Consultation Response from: KC Environmental Health (Pollution & Noise Control)

2022/93397 Highfields Centre, New North Road, Huddersfield, HD1 5LS

Discharge of conditions 3 (Construction Environmental Management Plan), 4 (cycle parking), 5 (electric vehicle charging), 6 (waste storage and collection), 7 (crime prevention), 8 (materials), 9 (windows schedule), 10 (boundary treatments), 11 (external lighting), 12 (sound insulation), 18 (landscaping) and 19 (Ecological Design Strategy) of previous permission 2019/90467 for conversion of former college buildings into 33 apartments including demolition of link canopy, partial demolition of link building, erection of additional storey to link building, and internal and external alterations (Listed Building within a Conservation Area)

Responding Date:
 8th July 2024

Scale	Sheet	Date	Drawn	Checked	Drawing Number	Revision
1:100	1/200	08.03.18	mjd	mjd	18.007(2)-001	0

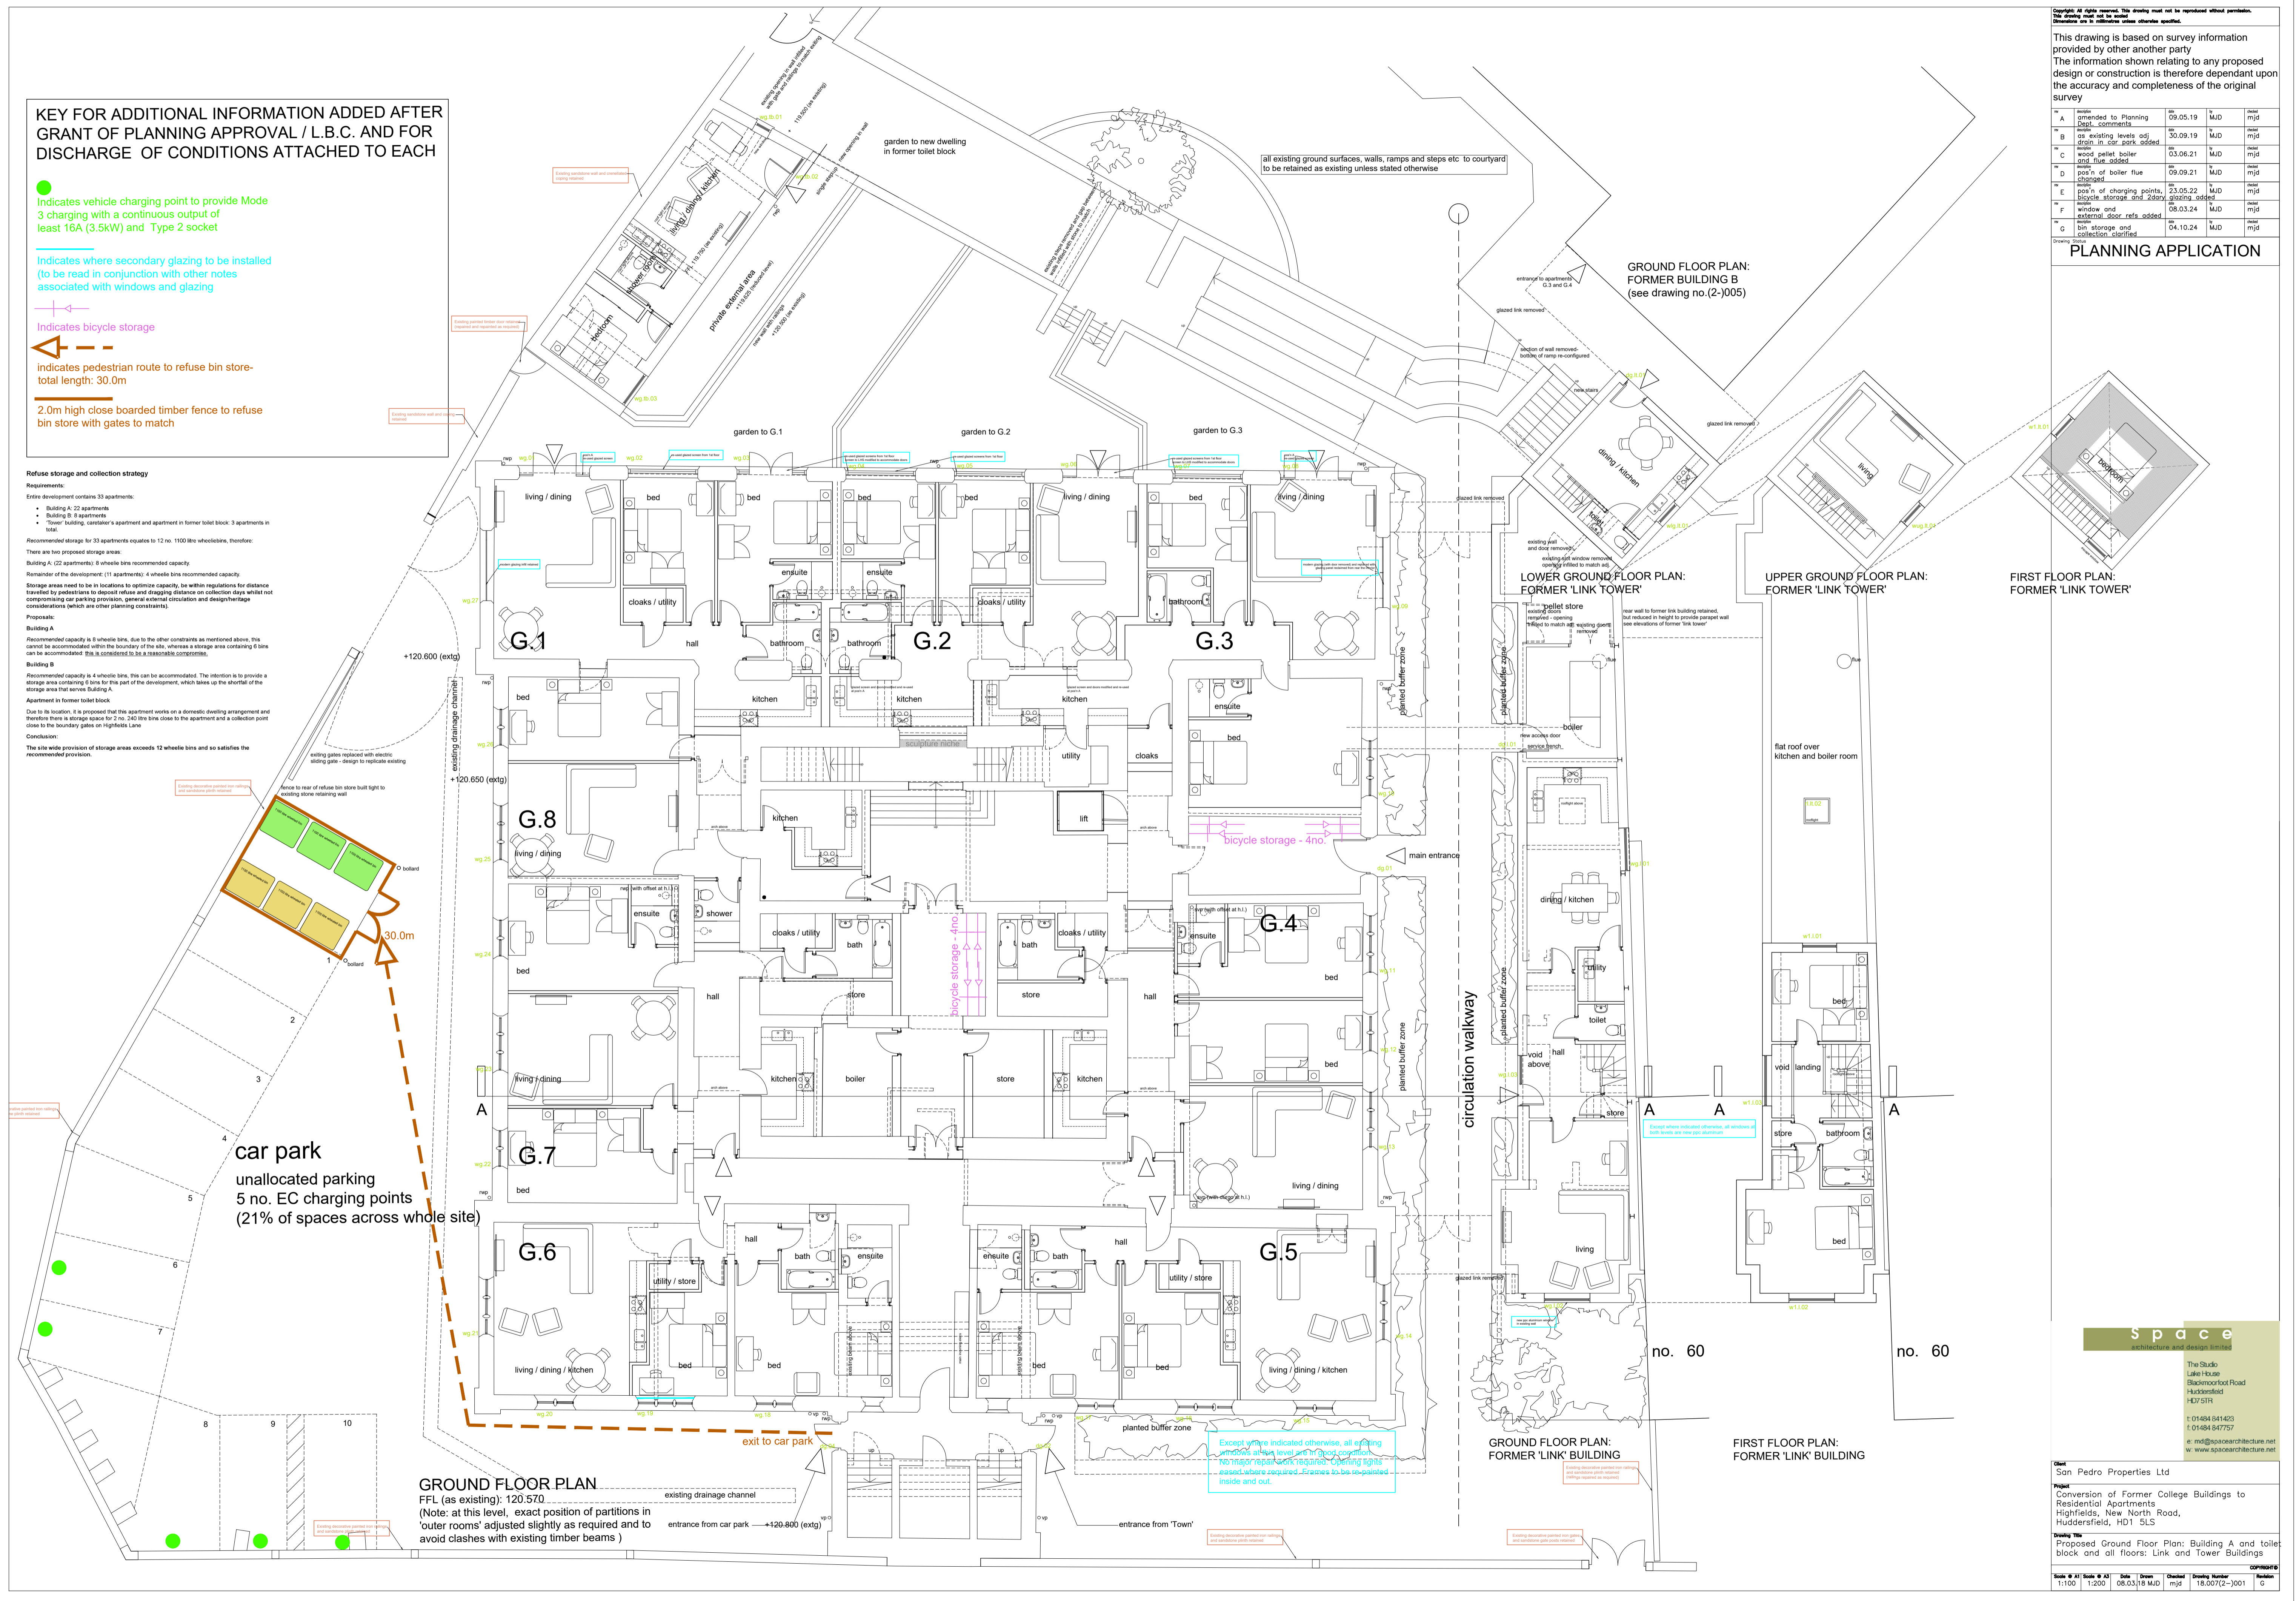
In support of the discharge of condition 5 a plan Proposed Ground Floor Plan: Building A and toilet block and all floors: Link and Tower Building (18.007(2-)001.F-A1), shows 10 parking spaces with 5 EVCP'S detailed, annotation clarifies Mode 3 charging with a continuous output of 16A/3.5Kw. Whilst we accept this information, we made it clear in our earlier response dated the 14th of February 2023, that the applicant is required to provided details of all the parking and clarify if this is allocated or unallocated parking, therefore the information is insufficient to discharge the condition.

- *One Standard Electric Vehicle Charging point (of a minimum output of 16A/3.5kW) for each residential unit that has a dedicated parking space; and*
- *One Standard Electric Vehicle Charging Point (of a minimum output of 16A/3.5kW) for every 10 unallocated residential parking spaces.*

Due to the reasons listed above the submitted information is insufficient therefore we recommend that condition 5 is not discharged at this time.
